Planning Rationale Addendum

4380 Trail Road

1.0 Addendum Overview

1.1 Planning Technical Circulation Comments and Consultant Responses

PROJECT No.	DATE	DRAWING No.
OTT-21023795-A0	27/04/2022	C200-4

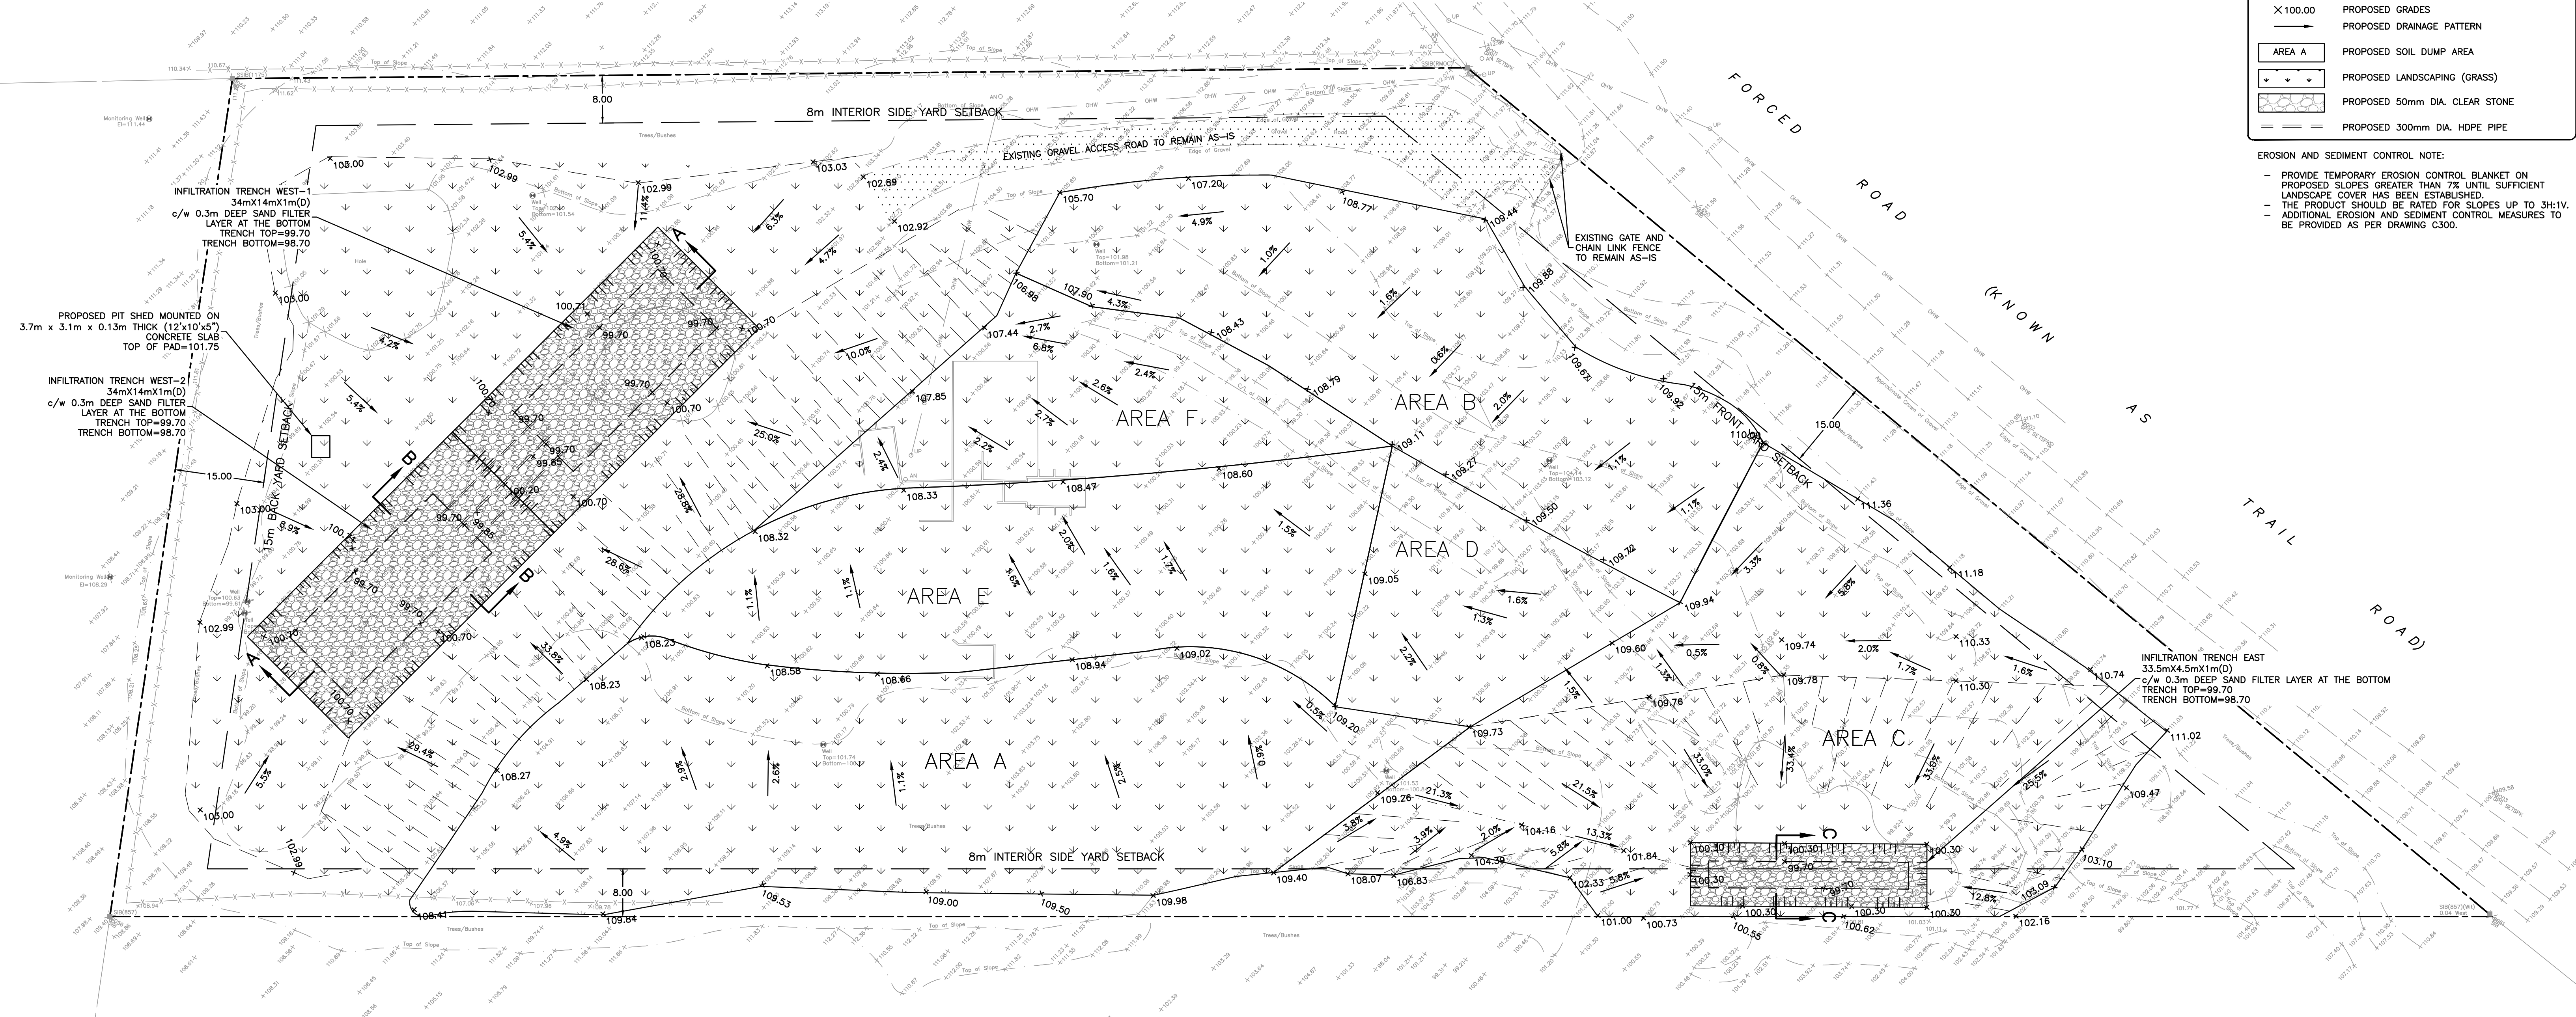
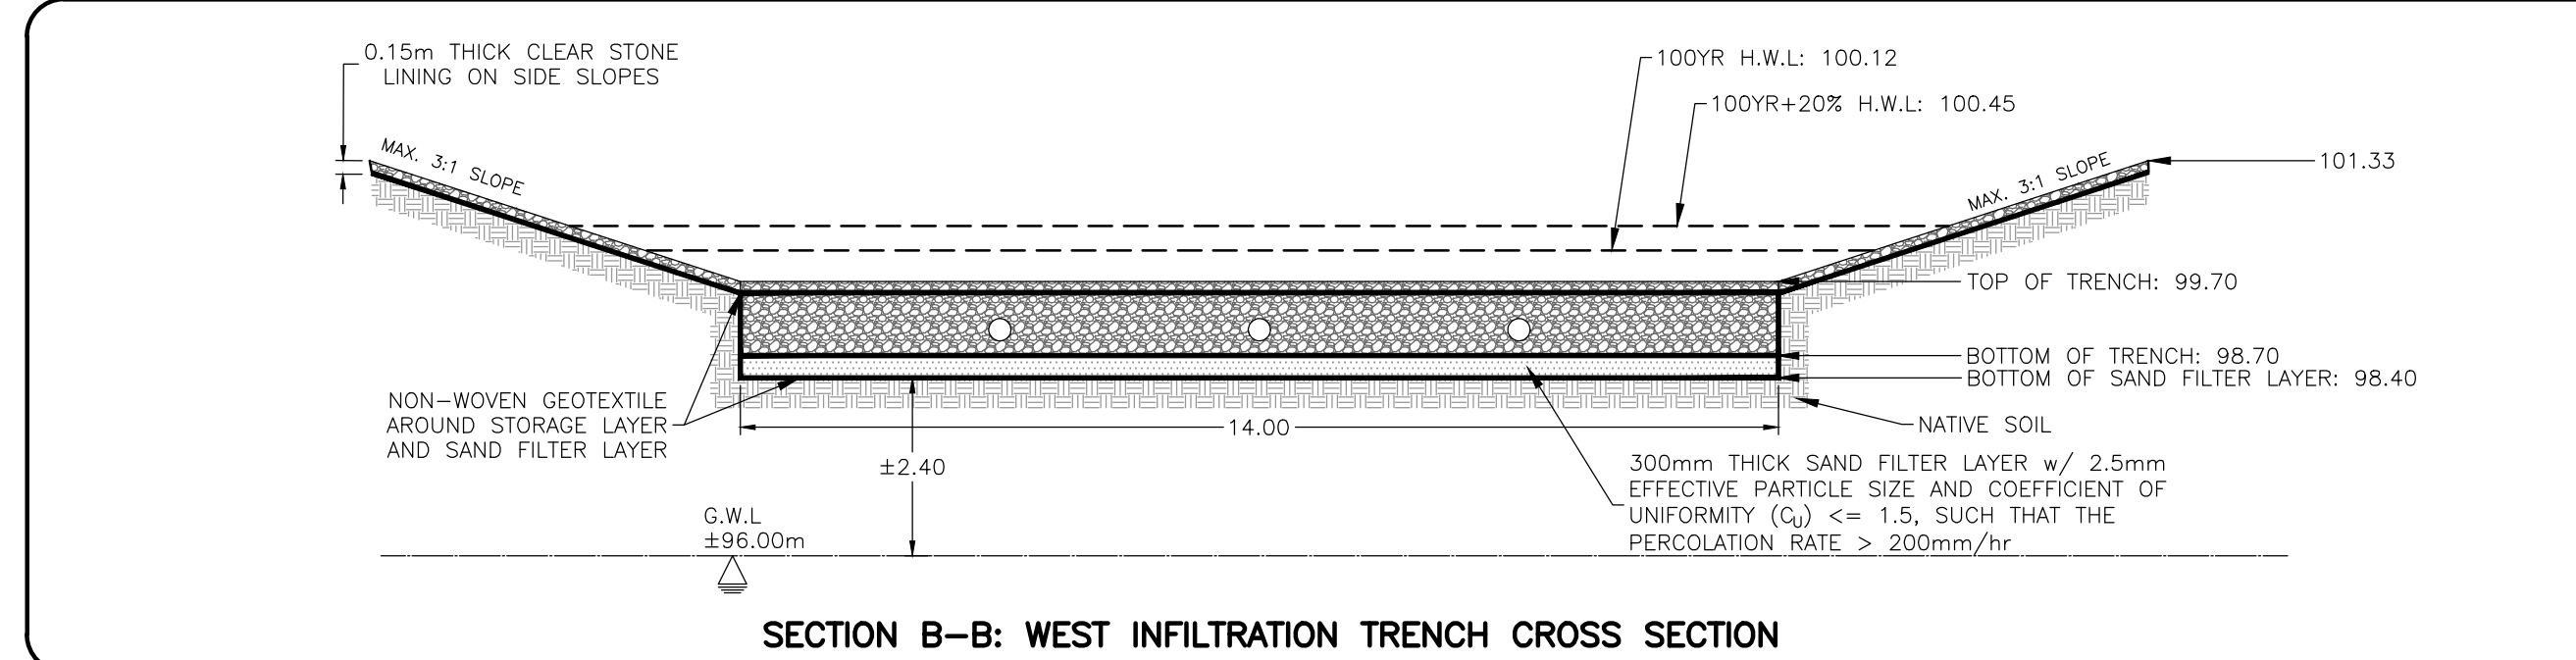
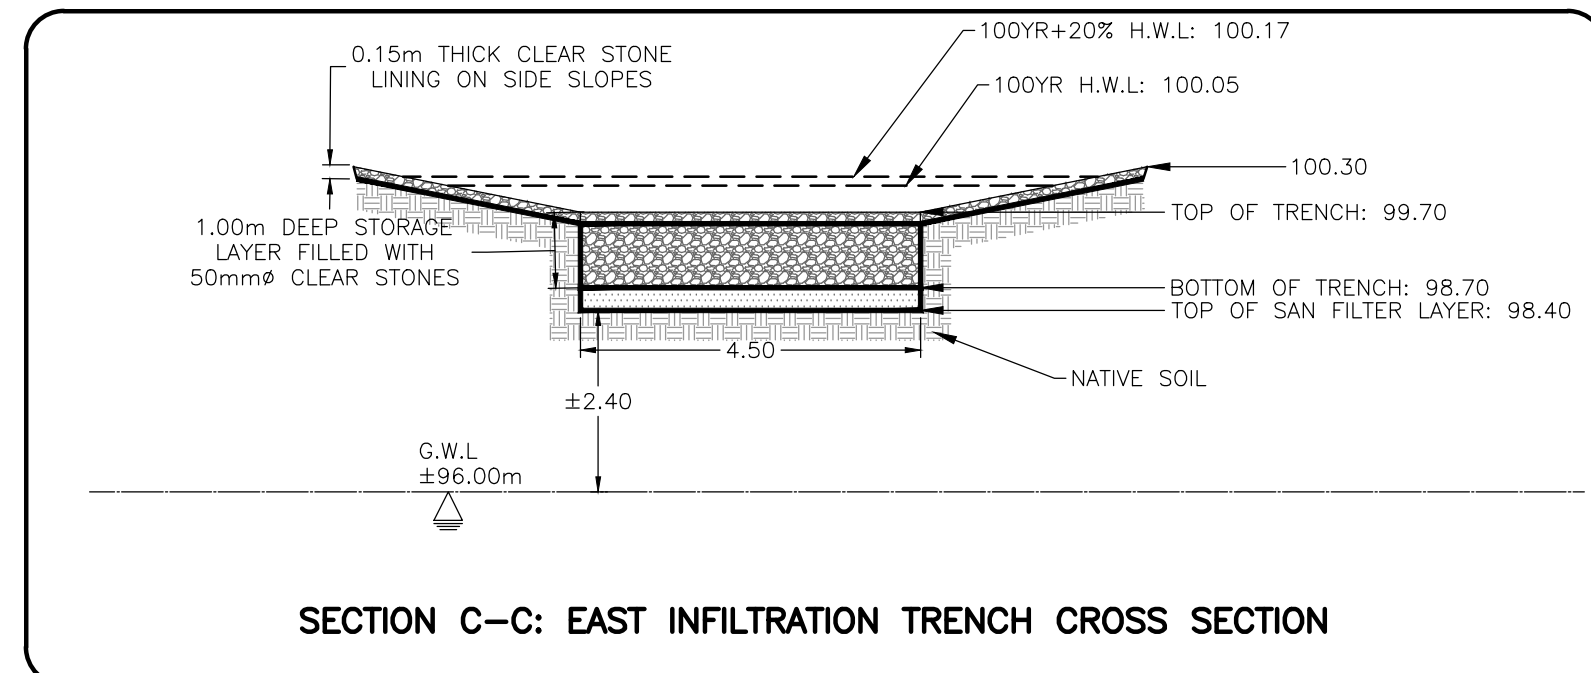
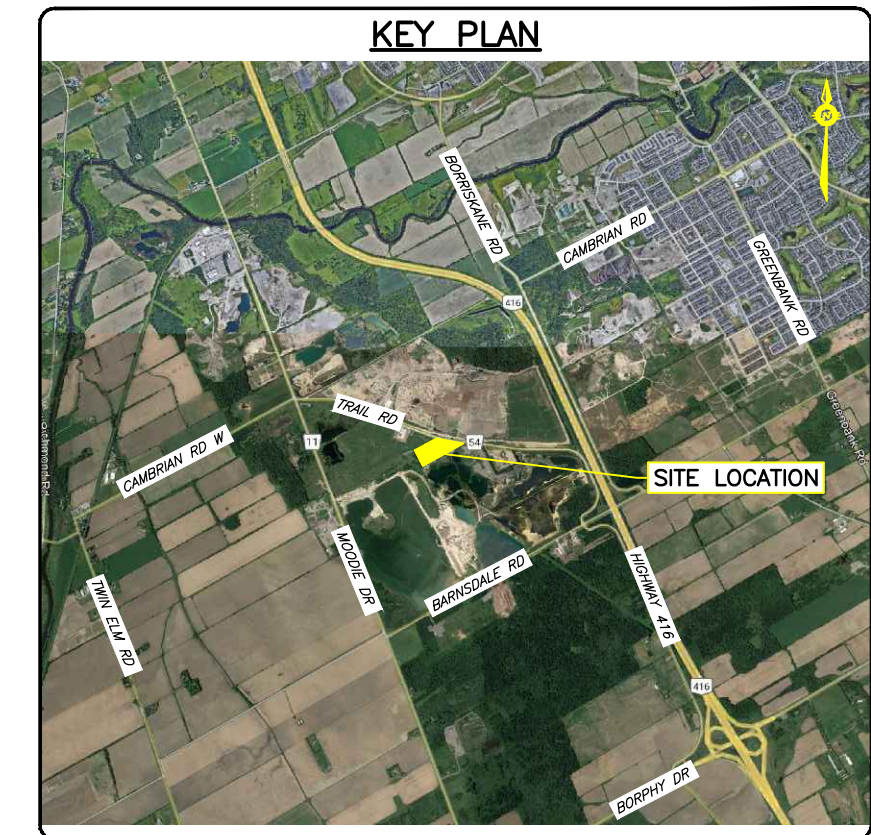
- 4.11 Clarify how infiltration areas shown on the Site Plan relate to the liquid storage and temporary dry storage areas identified in the Planning Rationale. References to "Area A" and "Area B" should be clarified, as the Site Grading and Drainage Plan also utilize similar naming.

Please see the accompanying engineering plans and studies that speak to the requested information in fulsome description.
